Date: 1 July 2019

## **The Planning Act 2008 and The Infrastructure Planning (Examination Procedure) Rules 2010 (as amended) – Rule 17**

### **Application by Highways England for an Order Granting Development Consent for the A30 Chiverton to Carland Cross Scheme**

#### **Request for Further Information**

Drawing Title: **FIGURE 2.1 GENERAL ARRANGEMENT PLANS SHEET 8 OF 8**

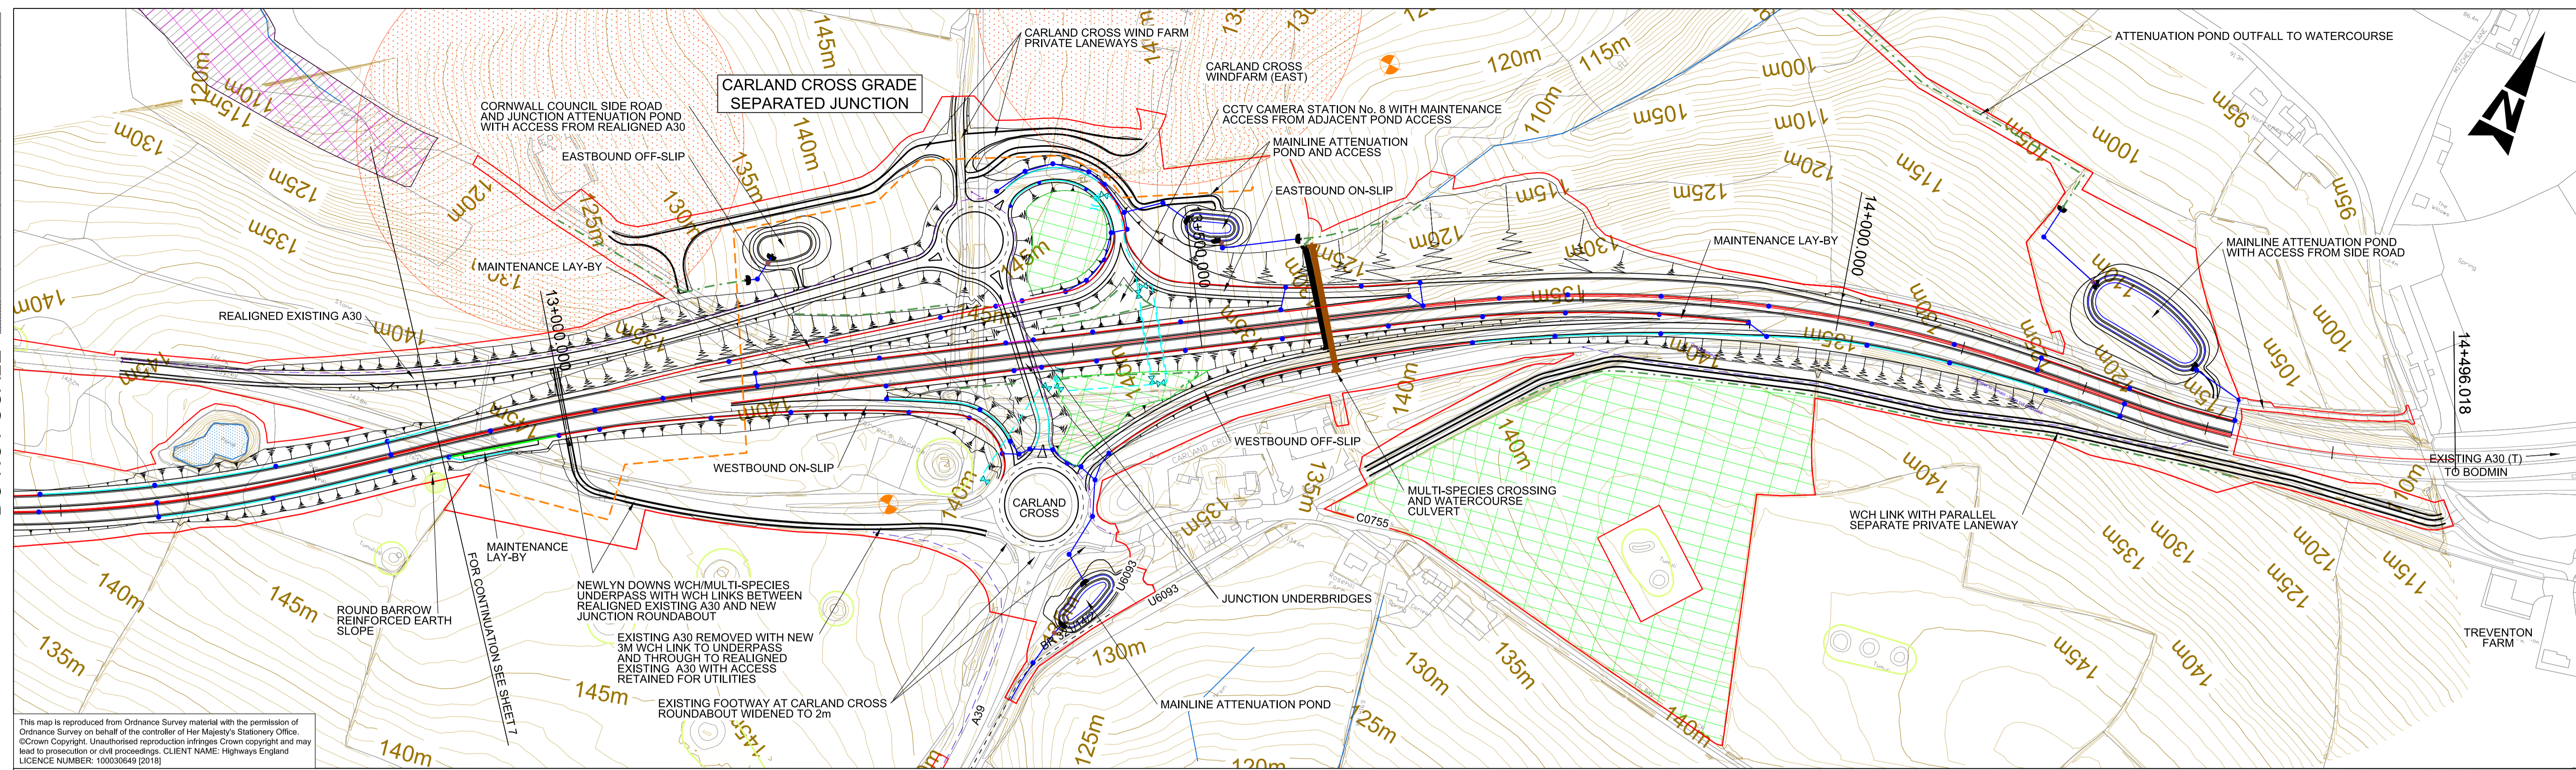
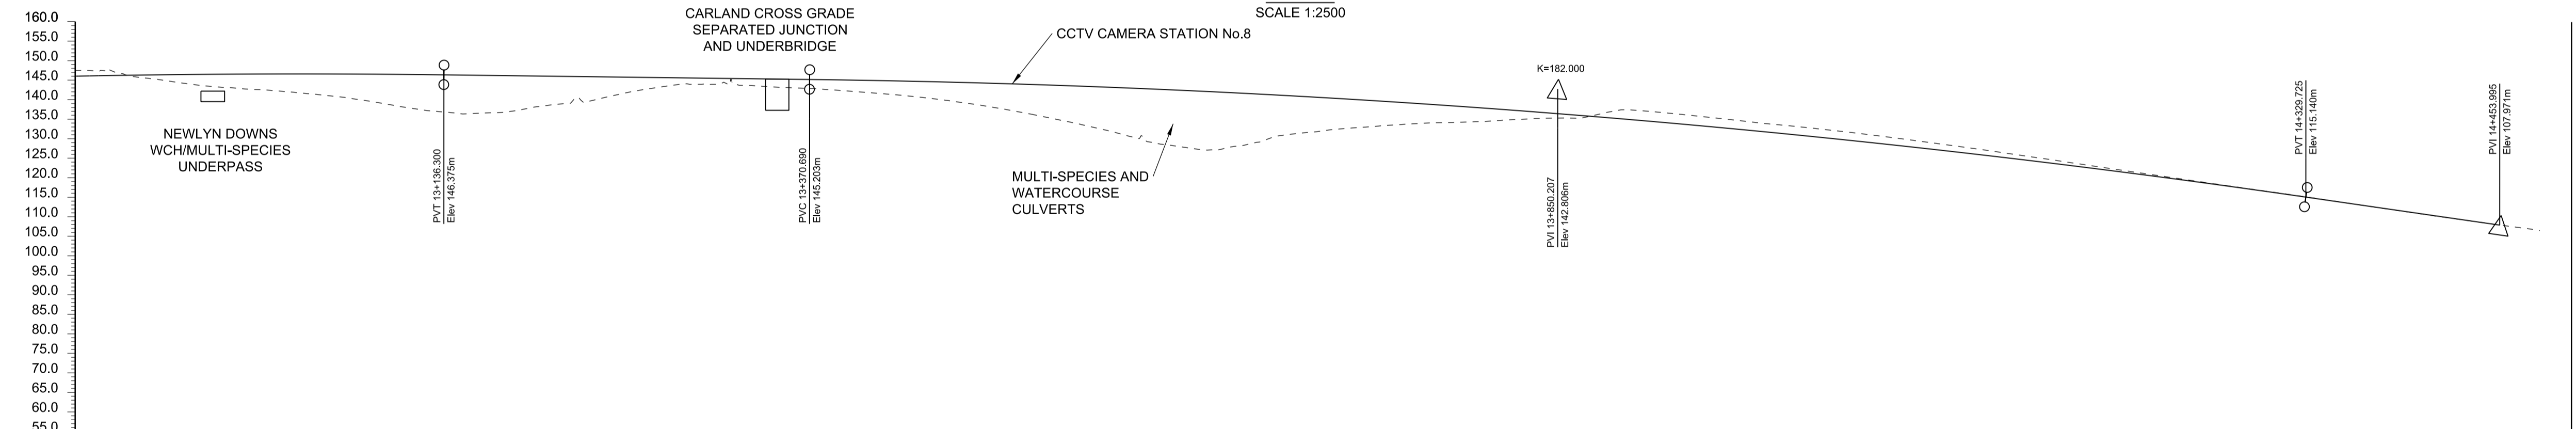
- The addition of a private access lane for wind farm abnormal load vehicles only, to the south of the realigned existing A30 to join into the northern roundabout of Carland Cross as shown on Sheet 8 of the General Arrangement and Section Plans (Document Reference 2.6(A)).
- The addition of a private access lane across the northern roundabout of Carland Cross junction for wind farm abnormal load vehicles only, as shown on Sheet 8 of the General Arrangement and Section Plans (Document Reference 2.6(A)).
- Minor changes to the horizontal and vertical alignment of access lanes to the wind farm to improve access for abnormal load vehicles, shown as HA551502-

The ExA therefore accepts the request for non-material amendments as set out above.
